RE: Planning Application 24/00496/GPDCOM - more information is needed

**Existing Elevations**

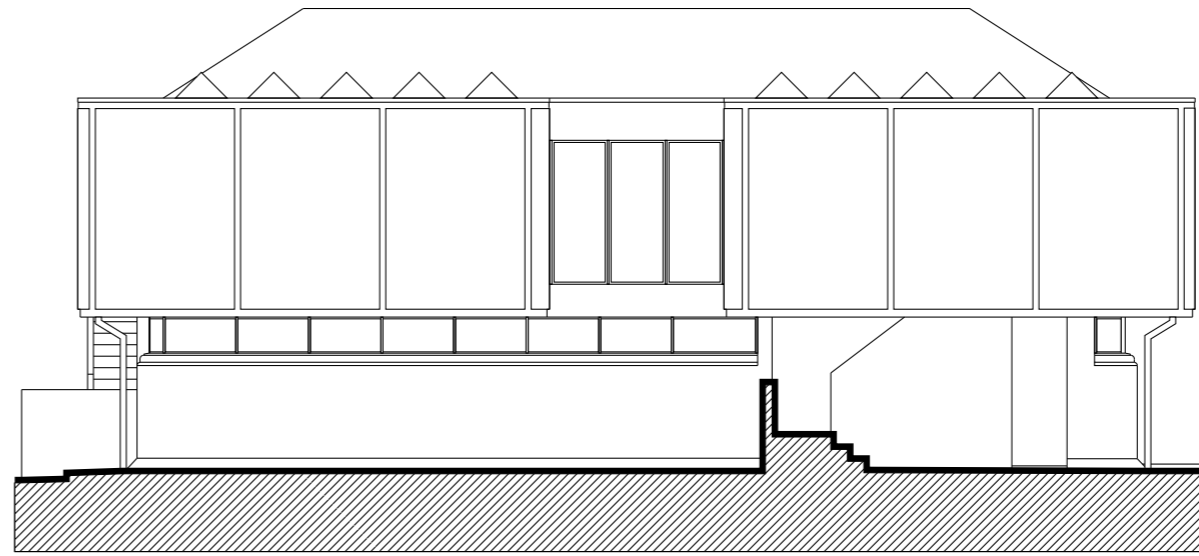
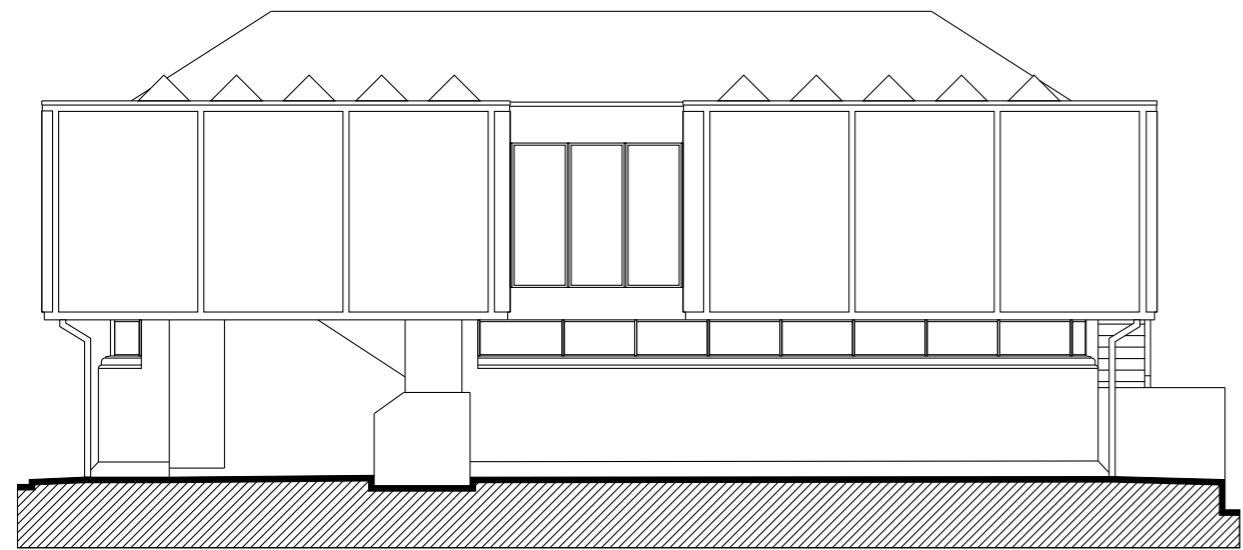
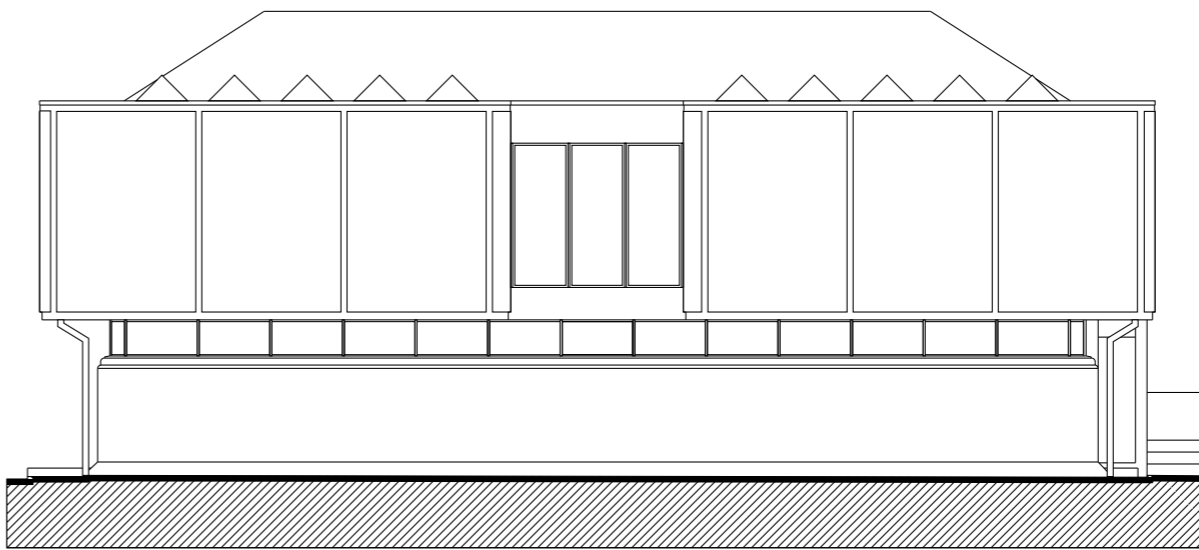
The requirements of Paragraph W go above and beyond the usual requirement for scaled plans in that they set out specifically that the proposed elevations of the dwelling (which are missing from this submission) should be marked up to show the dimensions of the doors and windows (which are also missing from the existing elevations of the building).

I must have an earlier revision as the version I have is not marked up with any dimensions.

Please provide the revisions of the existing elevations which is marked up with the heights of the windows and I will take this to my validation meeting on Monday to see if I am allowed to validate your submission without the proposed elevations.

I can only see the widths of the windows and not the heights, are the heights noted anywhere on the plan?

The drawing is to scale with a scale bar. That should enable the officer to measure the window heights.

Yes, the heights are shown on the existing elevations which are not proposed to change. That is a scaled drawings and so it is clear.

Proposed Floor Plans

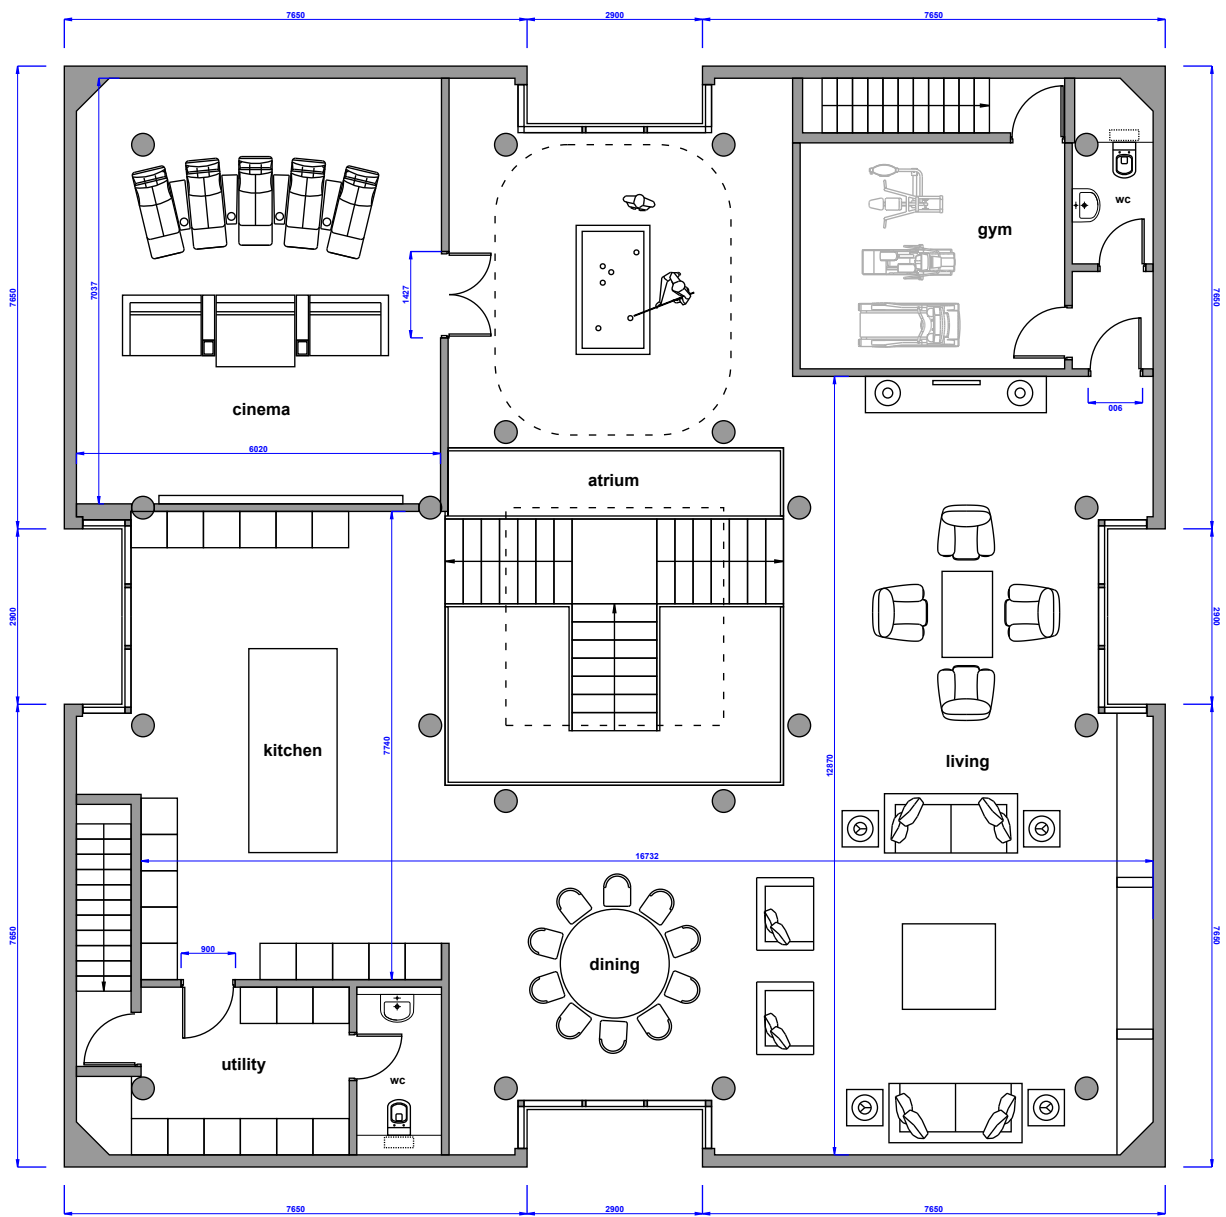
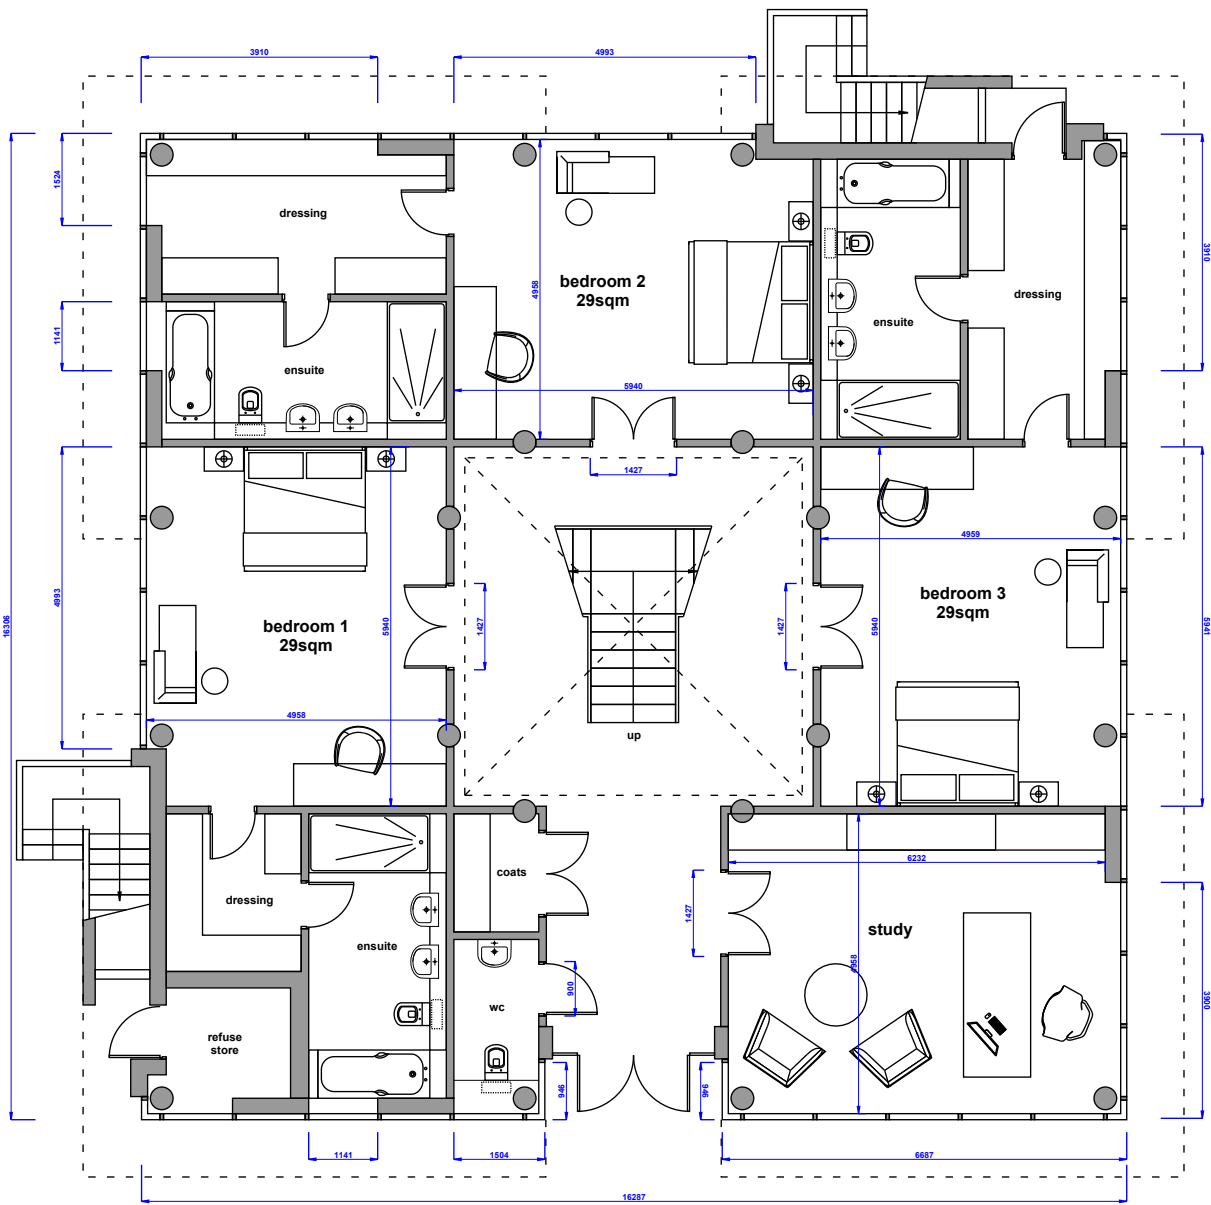
You state that the application proposes no external alterations, there are external alterations shown on your floorplans so if the application proposes no external alterations please amend your floorplans to reflect this fact.

Proposed Elevations

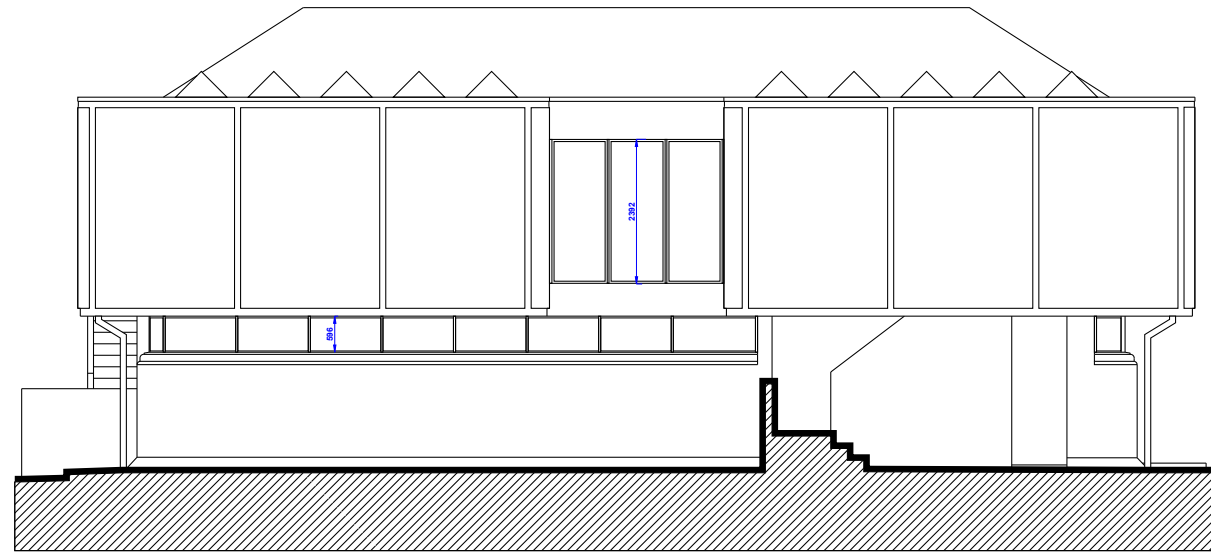
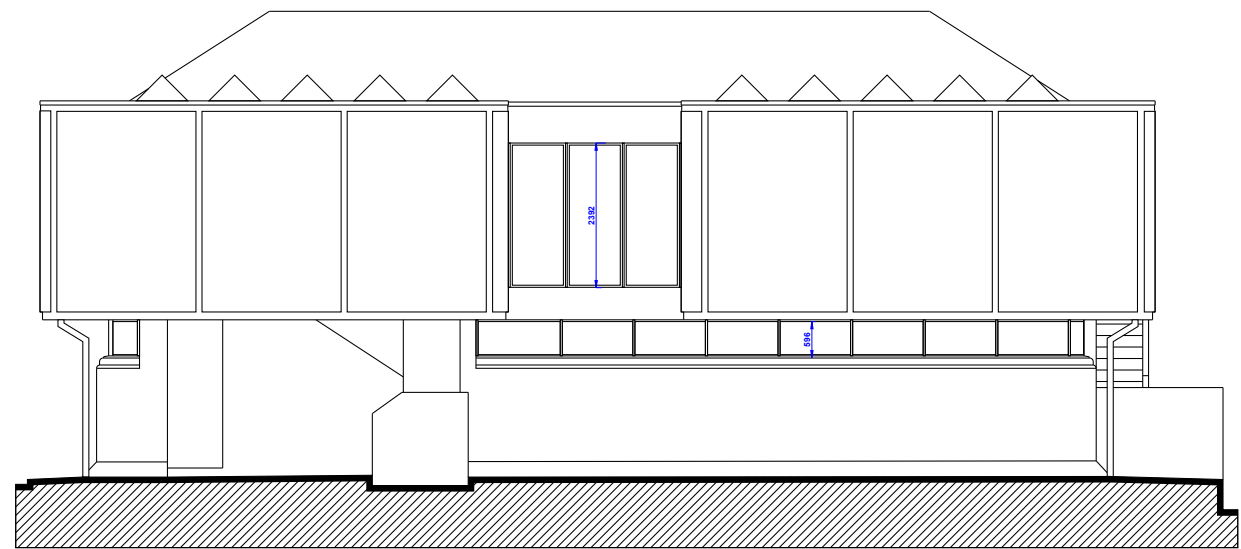
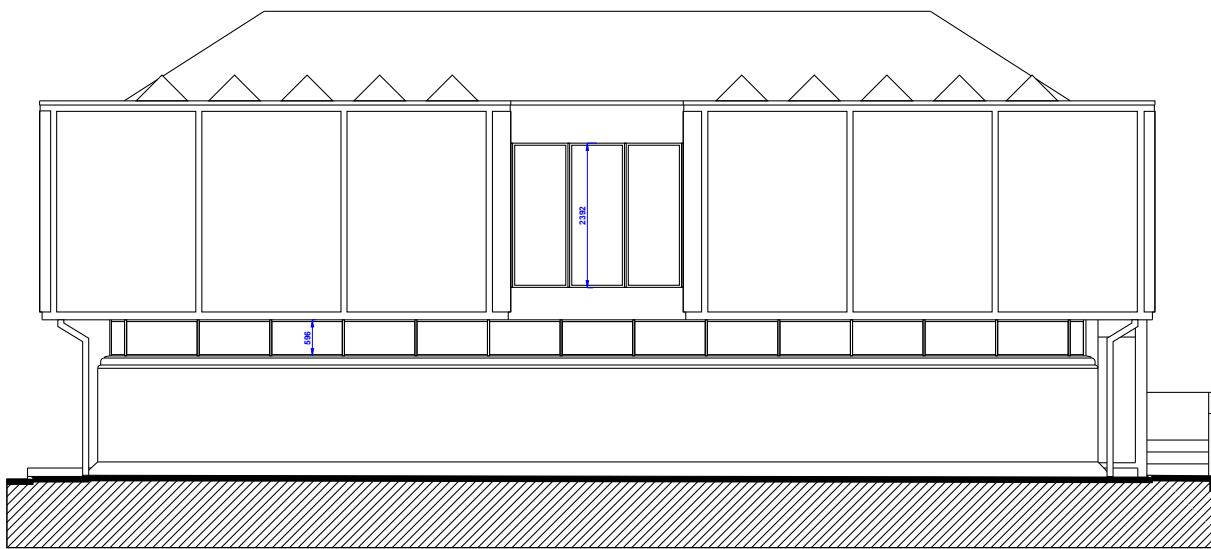
That is correct, I have the existing elevations of the building, it is the proposed elevations of the dwelling which are missing from your submission.

Please find attached a set of 'proposed elevations', which now detail the dimensions of the windows (height). The widths are shown on the plans which you already have a copy of.
